Application by One Earth Solar Farm Ltd for an order granting development consent for the One Earth Solar Farm

The Examining Authority's written questions and requests for information (ExQ3)

Issued on 19 November 2025

*Figure C.2: Impacts from Unplanned Emissions at Eastern BESS Compound*

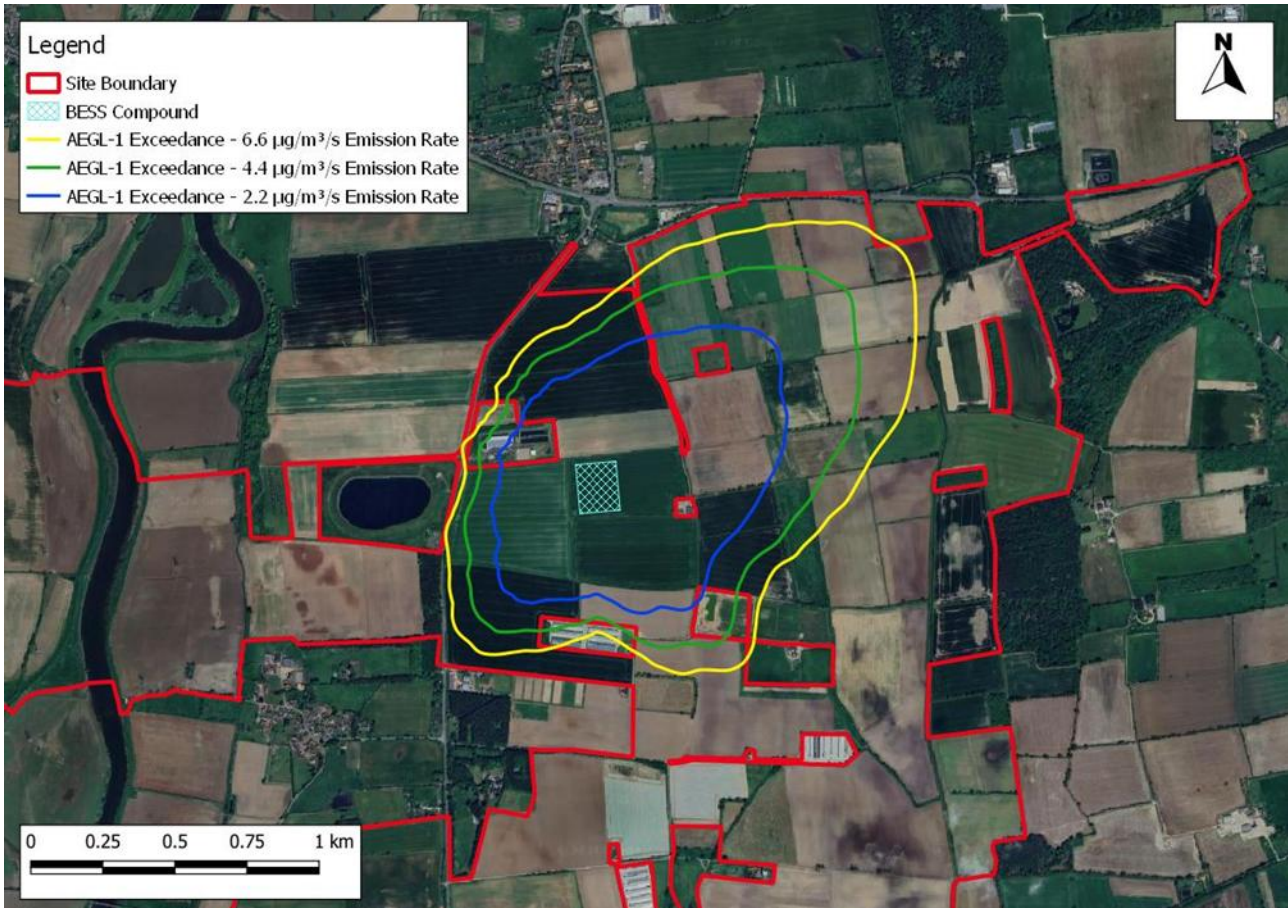
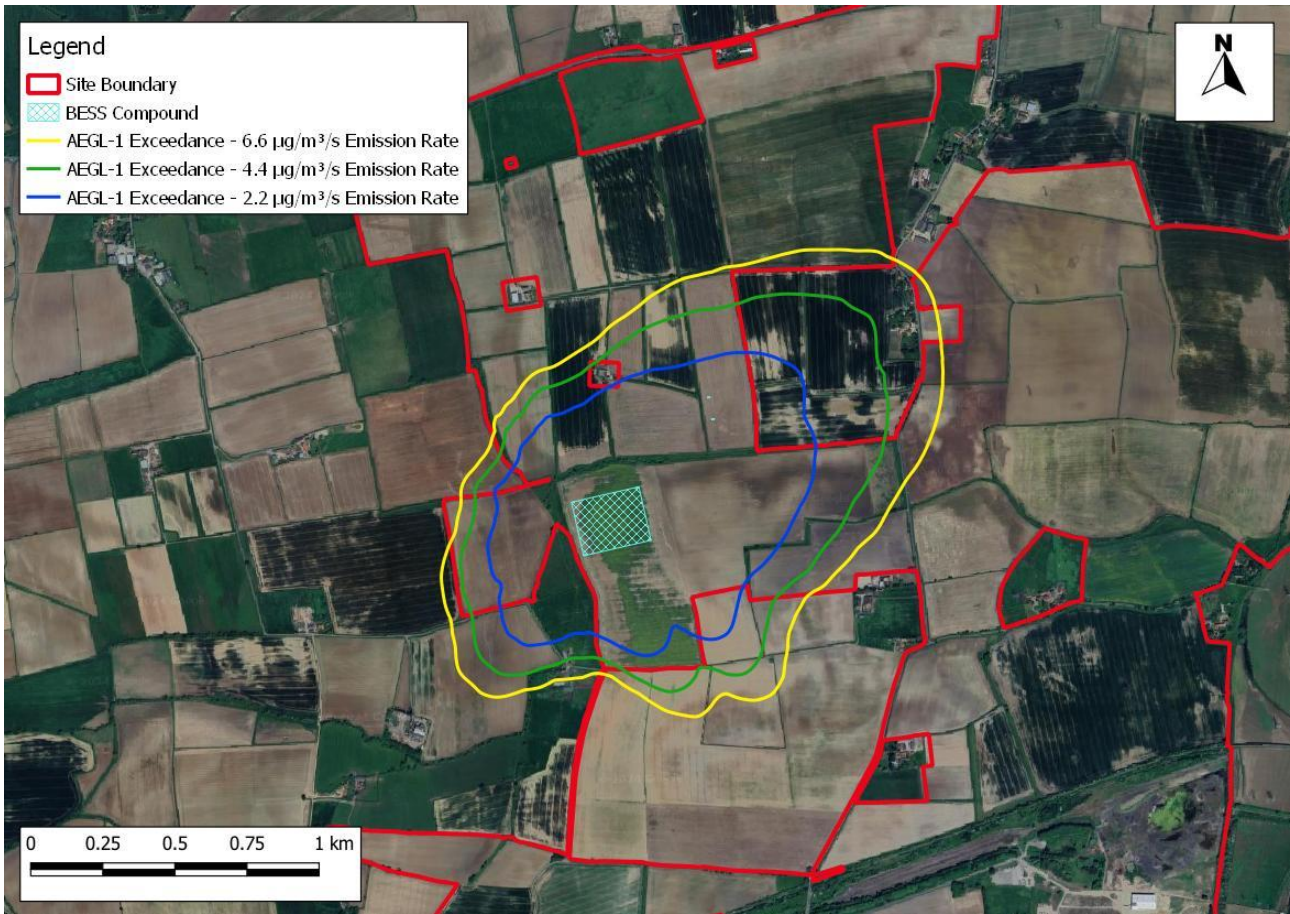
6. Air quality and emissions		
Q6.0.1	The applicant	BESS unplanned emissions At ISH3, an IP stated that in the assessment of unplanned emissions contained within the oBSMP [APP-183], it states that no sensitive receptors have been identified. Can the Applicant please confirm how this conclusion has been reached, including why poultry sheds and a reservoir in the locations affected have not been identified?
